1-11 Australia Avenue, Sydney Olympic Park

September 2011

Prepared for **Site 3 Development Company Pty Ltd**

Major Project MP10_0027
Preferred Project Report

Figure 14: West elevation

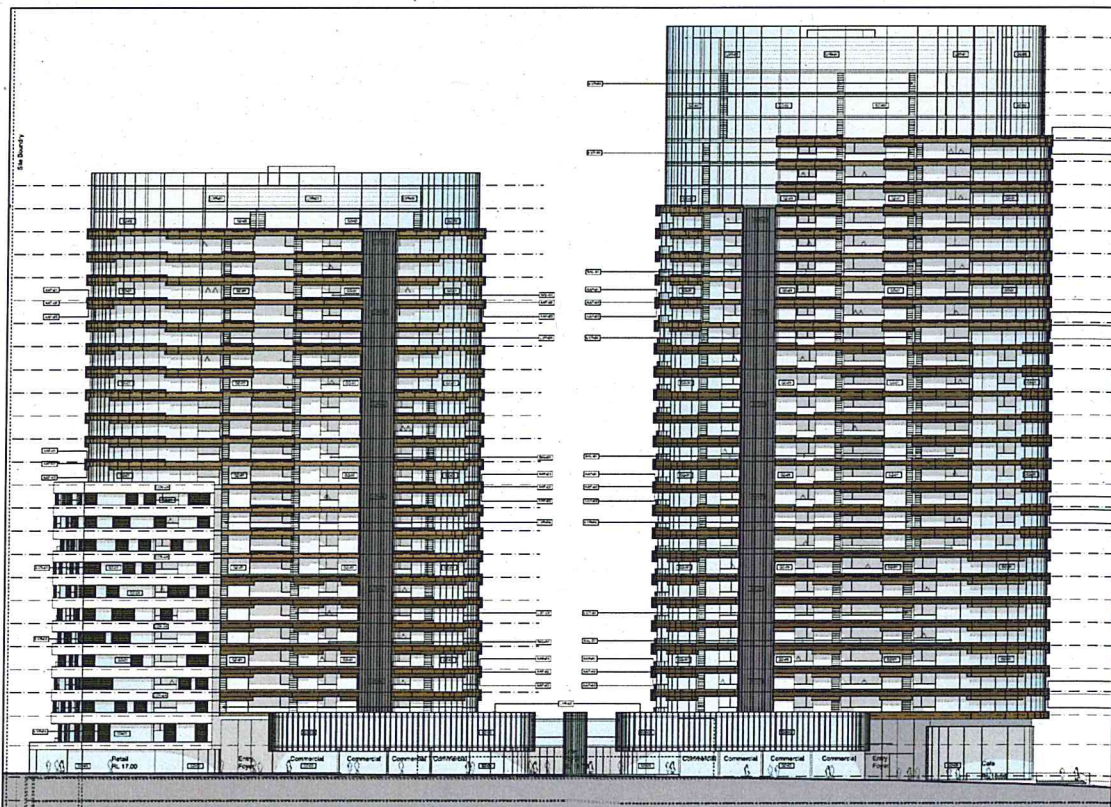
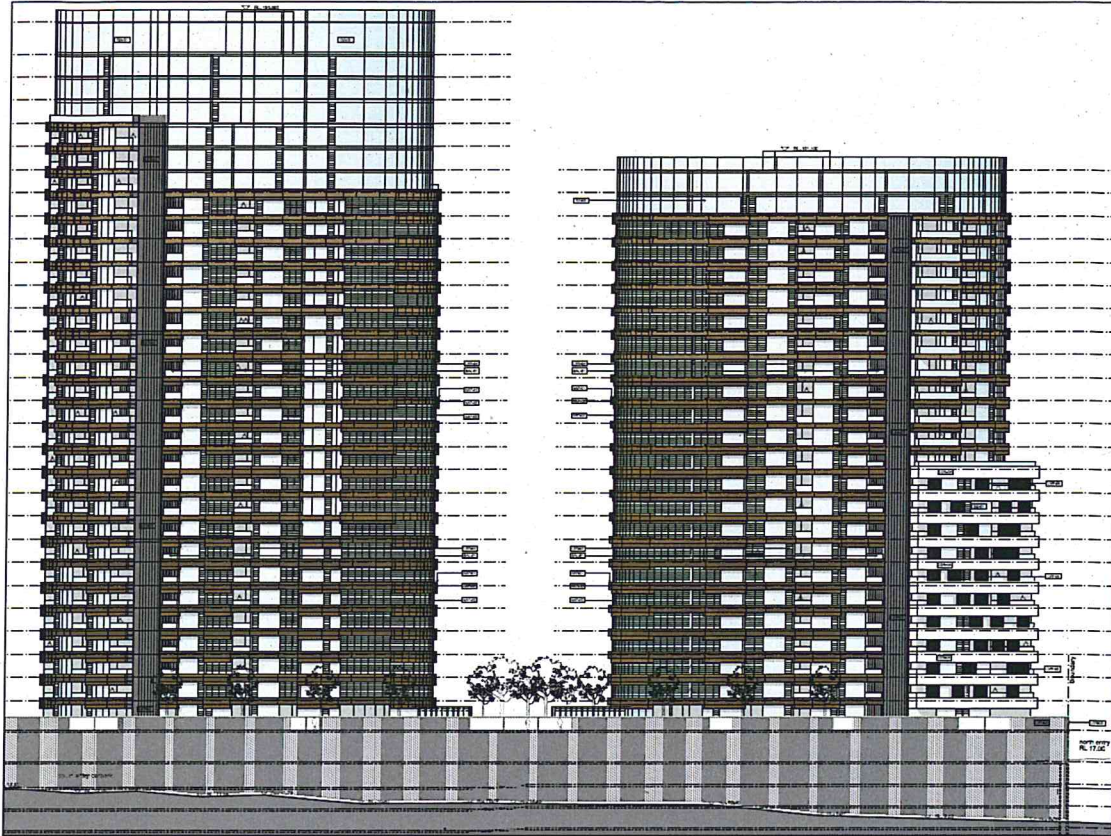
10 The proposed RSZ height (Tower 1. is 5.88m high; Tower 2 is 6.1m high) with minimal to nil setback from the respective tower parapets do not comply with MP 2030. The RSZ should have a maximum height of 5m and setback 3m (minimum) from the parapet in accordance with MP 2030. The non-compliance with the SEPP MD 2005 building height limit means that compliance with the RSZ requirement must be achieved. Further details should also be provided in relation to the coverage in plan of the respective	The RSZ is required to exceed 5m in height due to the size of the plant needed to operate the lifts for a tower of this heights proposed. Refer to the lift engineer's advice at Appendix O. The Master Plan limit on RSZ height applies to all buildings, irrespective of their overall height and servicing and lifting requirements. In Tower 1 the RSZ is integrated with the form of the roof, minimising its visual impact and complies with the maximum 5m height limitation. In Tower 2 the RSZ is surrounded by the glassed wall which extends to the top of the building and visually encloses the RSZ and has a height of 5.9m. This design approach is consistent with the controls

Issue	Response
RSZ.	64.6.5 (5) which states that: <i>"The design of rooftop structures is to be integral with the overall building design".</i> The proposed RPZs for both Towers satisfies the intent of this control, by their integration with the curved tower forms. The RSZ on Tower 2 mimics the elliptical form of the residential floor plate below. The roof plant and lift over runs are screened behind the curved curtain glazed wall, which provides an architectural feature at the top of the tower buildings .
11	Compliance with RFDC building separation requirement is noted. However, the MP 2030 provision (Part 4.6.8) is above and beyond that of the RDFC, and requires towers (above 26m) to have minimum of 40 metre separation. Accordingly, this matter is to be adequately addressed by the Proponent and / or separation between Towers 1 & 2 should be increased beyond the 24m currently proposed. The elliptical forms of the towers taper to the closest point of 23.64m. This separation distance occurs only at the closest point between the two towers. Figure 5 illustrates that the separation between the buildings. The two elliptical towers are angled and setback from Australia Avenue, so that the impacts of adjacent habitable living rooms and private open spaces are minimised. Living rooms are not directly facing each other in this location. The development is very close to complying with the RFDC in that for that part of a building that is above 25 metres in height, the required separation distance is at least 24 metres. Furthermore, the design competition endorsed two towers instead of three for the Stages 2 and 3 site. This design strategy allows for usable common open space to be created at the southern end of the site at ground level. Refer to Table 1 for further justification for the proposed separation distances.

Figure 25: Vertical slots provided which separates each of the towers into two wings

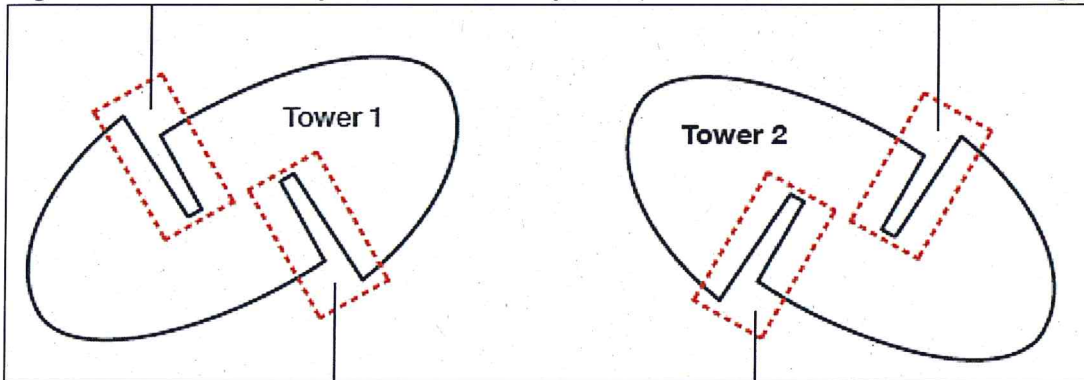
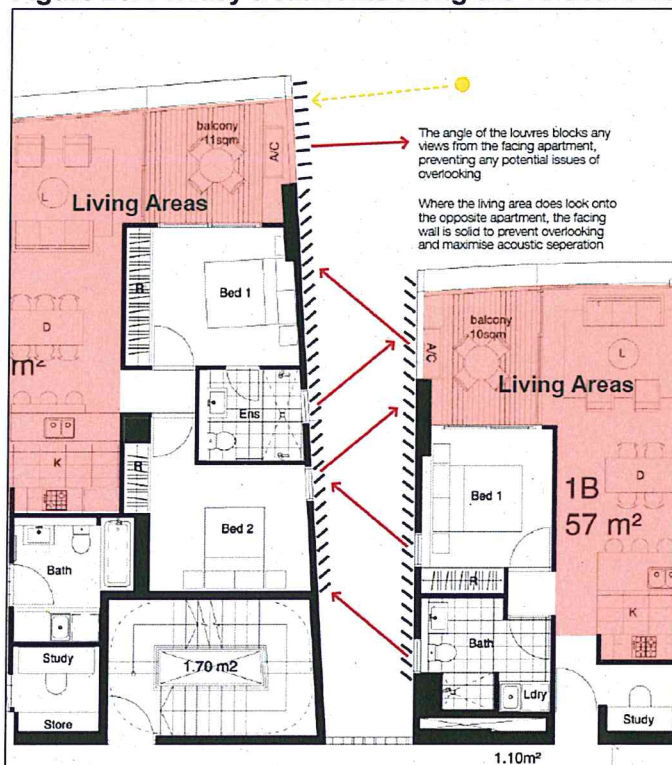
18	The configuration of the vertical slots is still problematic. The narrow dimensions and the lack of openness to the sky provide little privacy and amenity to the habitable rooms facing onto the slots. If the alternative window configuration can't be accommodated, then the width of the slots, and angle of splay should be increased. Bates Smart have provided the following further explanation for the use of the vertical slots, having regard to privacy and amenity of habitable rooms facing the slots: <i>"The vertical slots are intended to maximise natural ventilation across the development, whilst enhancing the amenity to the common corridors. Potential issues with privacy and overlooking between facing units is counteracted by the use of angled vertical louvers.</i> <i>The use of a vertical slot is an increasing common feature of highrise residential towers, as it enables the buildings to meet the cross-ventilation requirements of SEPP65. The examples in the following pages illustrate how it a vertical slot has been incorporated into high-end residential buildings in Sydney. In both examples the slots are narrower than those proposed for Site 3 (Stages 2&3), and do not incorporate any louvers, or staggering of windows to prevent overlooking.</i>

Issue	Response
	<i>All living spaces (kitchen, dining room and living room) have been placed away from slot to maximise the distance between the most habitable rooms. The only rooms facing onto the slot are bedrooms and bathrooms, including ensuites, meaning the main living spaces benefit from the maximum amount of privacy. The windows looking out of the rooms facing the slot are staggered to maximise the sense of separation".</i> The bedroom windows facing onto the vertical slots have angled louvres to restrict direct overlooking between habitable rooms facing the vertical slots. The habitable living rooms do not face onto the slots, instead are oriented to balconies and the views beyond and afforded good privacy and amenity. It is not considered necessary to open up the vertical slots any further as adequate levels of amenity will be achieved for the habitable rooms facing into the slots. The examples of projects, which have been designed by highly respected international architects at the former Calton and United Brewery Site on Broadway known as Central Park, by Jean Nouvel (approved by the Minister for Planning) and Lumiere Apartments on George Street in Central Sydney approved by the Central Sydney Planning Committee). These projects demonstrate that narrower slots, with lower quality amenity and privacy for habitable rooms have been accepted by planning authorities in Sydney. The proposed splayed design is a good design solution to optimise natural ventilation of the internal corridor spaces and to units for proposed buildings.
